OUT20/5236

**Sydney Metro West (SSI-10038)  
Advice on EIS**

I refer to your email of 30 April 2020 to the Department of Planning, Industry and Environment (DPIE) Water and the Natural Resources Access Regulator (NRAR) about the above matter.

Figure 12-3: Clyde stabling and maintenance facility construction site – Heritage items and conservative areas

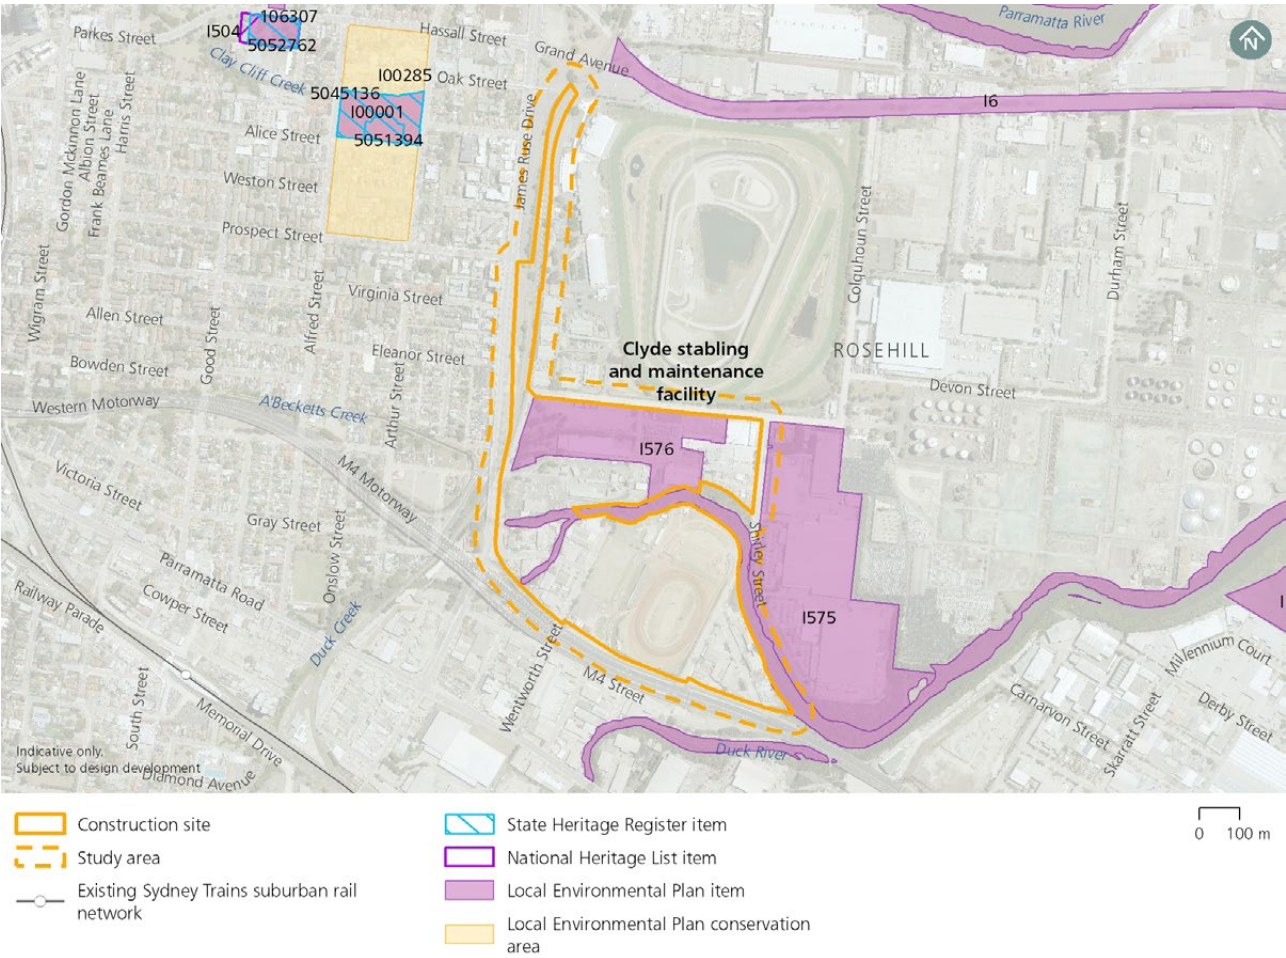
- The EIS identifies a creek crossing and partial realignment works at Duck Creek and A'Becketts Creek located near the proposed Clyde stabling and maintenance facility. The EIS should provide detail of proposed works on waterfront land and demonstrate design in accordance with the NRAR Guidelines for Controlled Activities located here - <https://www.industry.nsw.gov.au/water/licensing-trade/approvals/controlled-activities/guide>

Figure 18-2: Existing groundwater bores within one kilometre of Stage 1

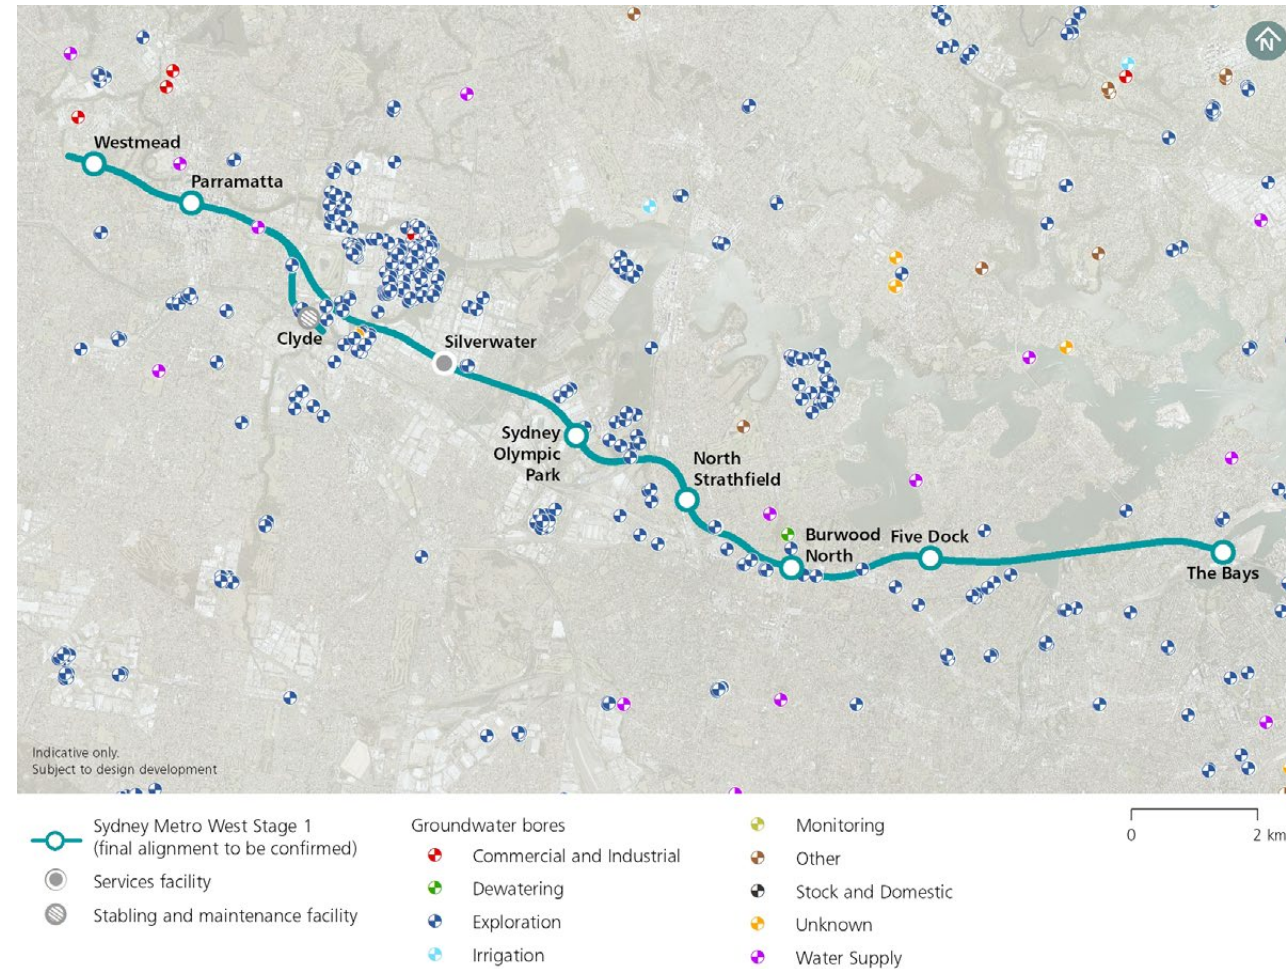
- Salinity monitoring bores positioned between estuarine areas and the Stage 1 construction sites should be included in all future monitoring programmes.

- Include a detailed groundwater level and quality monitoring programme for each development site.
- Clarify the construction and groundwater ingress prevention methods to be used during excavation and the final construction state each excavation site will be finished at the end of Stage 1. Plus, how this will affect the groundwater ingress and drawdown.
